**WELWYN HATFIELD BOROUGH COUNCIL
EXECUTIVE DIRECTOR - PLANNING, PUBLIC PROTECTION AND GOVERNANCE**

DELEGATED APPLICATION

Application No: 6/2022/2146/ADV
Location: H R Owen Mosquito Way Hatfield Hertfordshire AL10 9WN
Proposal: Installation of signage to facade of east and west buildings together with site wide totem wayfinding signage
Officer: Ms Elizabeth Mugova

Recommendation: Granted

Drawing Title
**Ground Floor Site Plan
Signage Points**

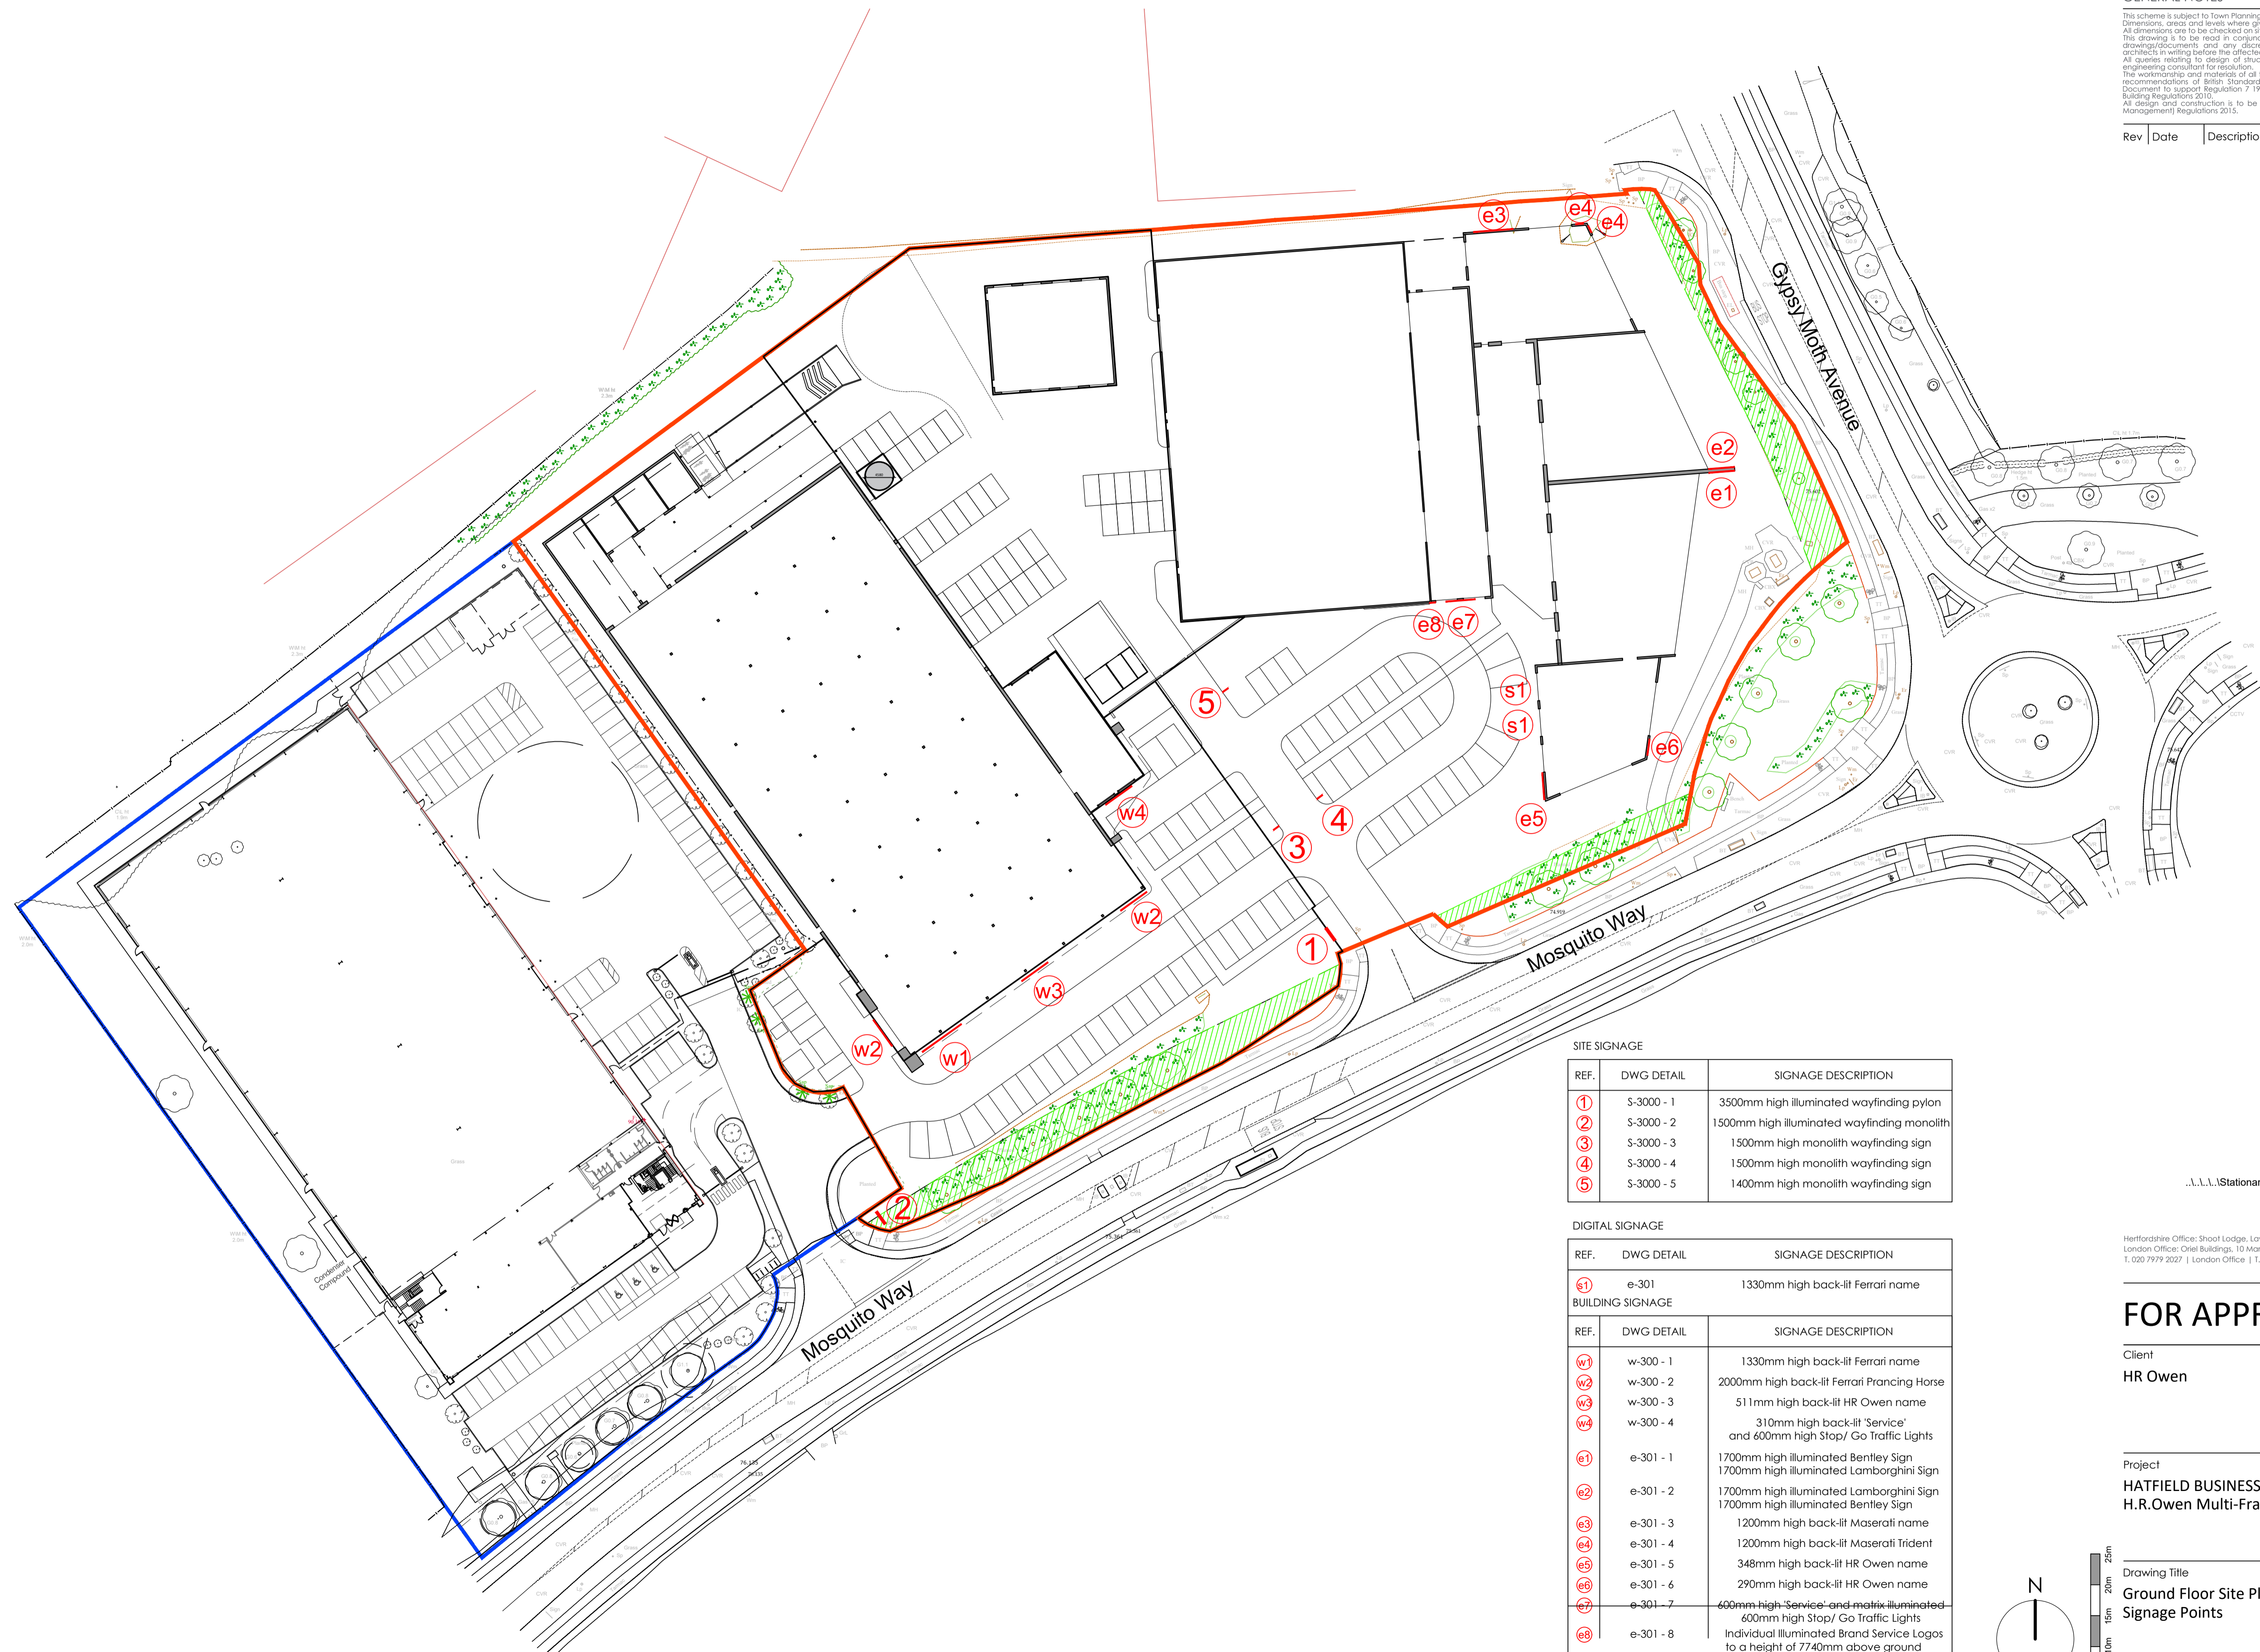
The applicant is advised to ensure that the location of sign 2 is not part of the public highway.

Drawing Title
Site Plan
Signage Elevations

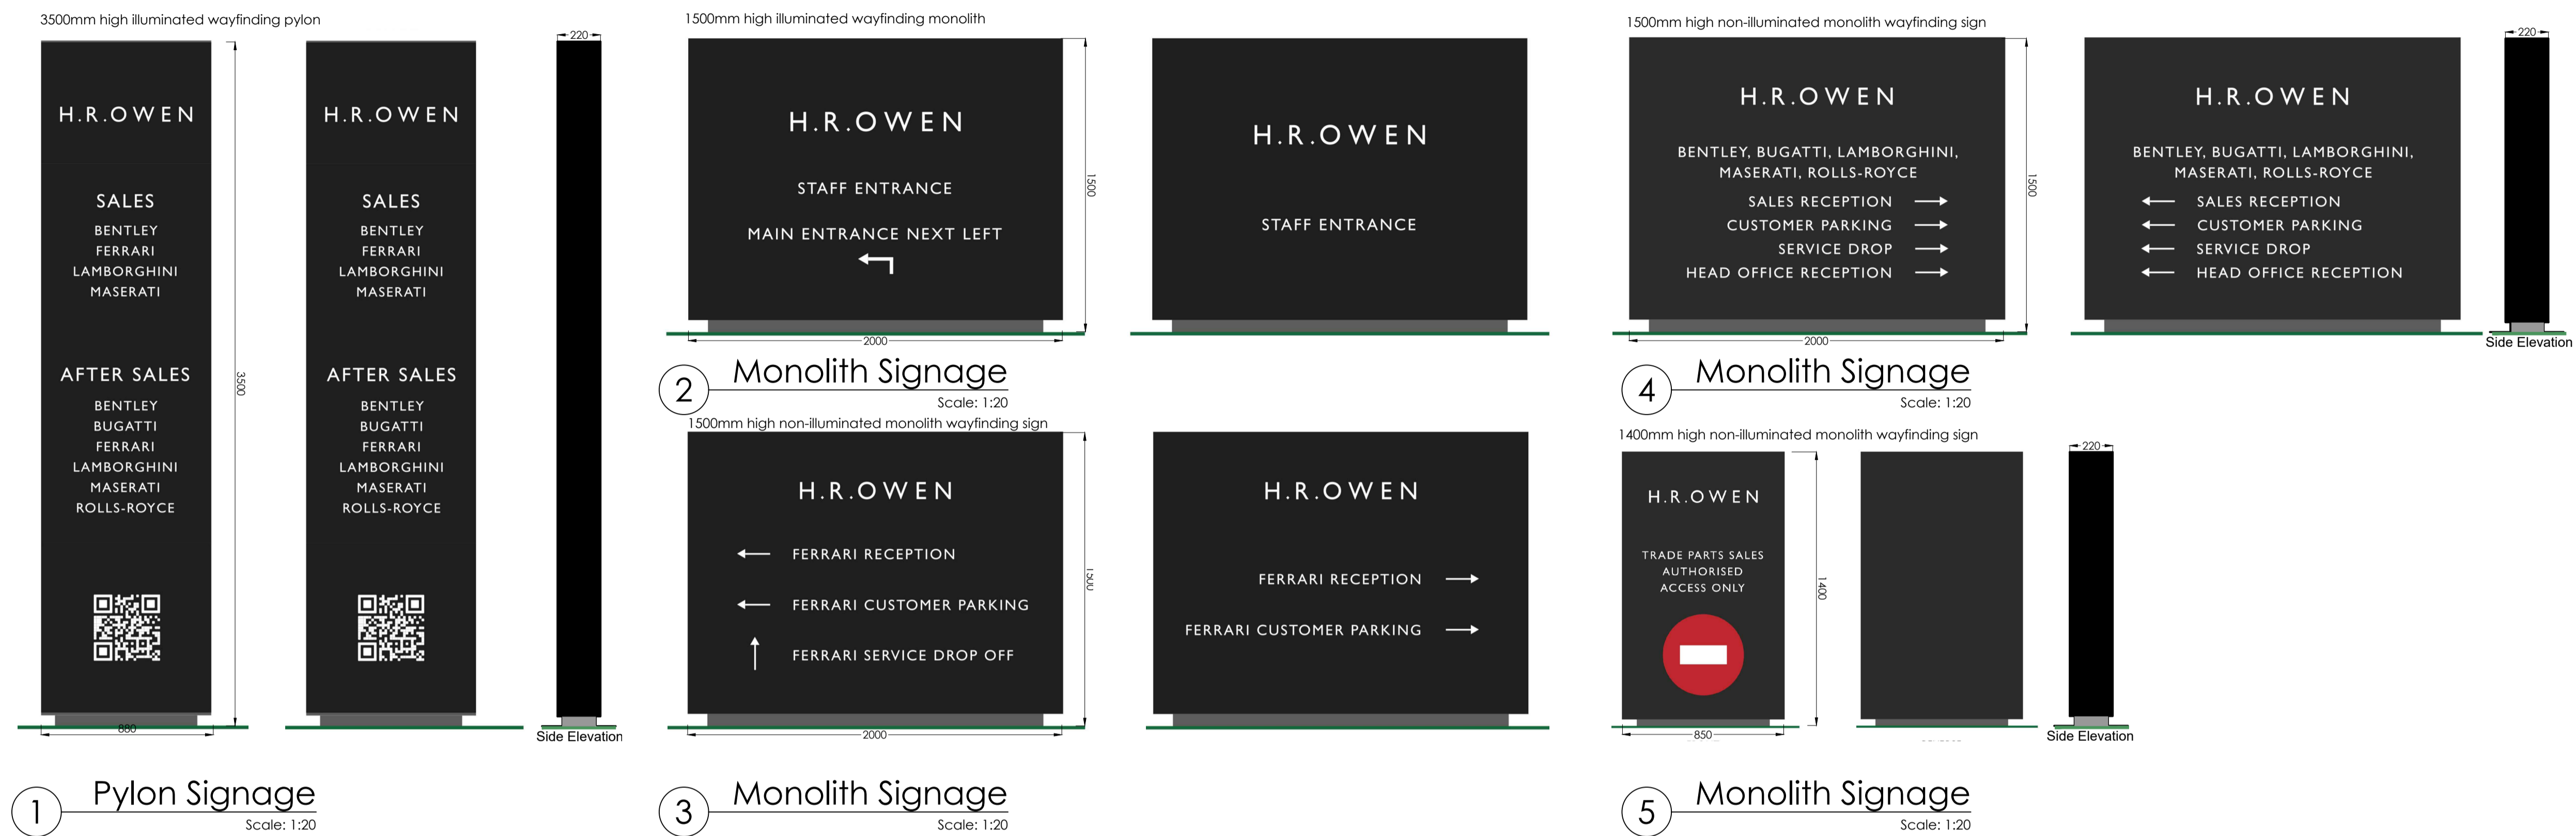
The position of the buildings relative to the roads means that the signs will not be directly in the line of site for drivers or distract from any existing road signs or signals. The wayfinding signs are of a simple design and are unlikely to distract from any other road signage. The area is already street lit so the impact of the illuminations would be limited.
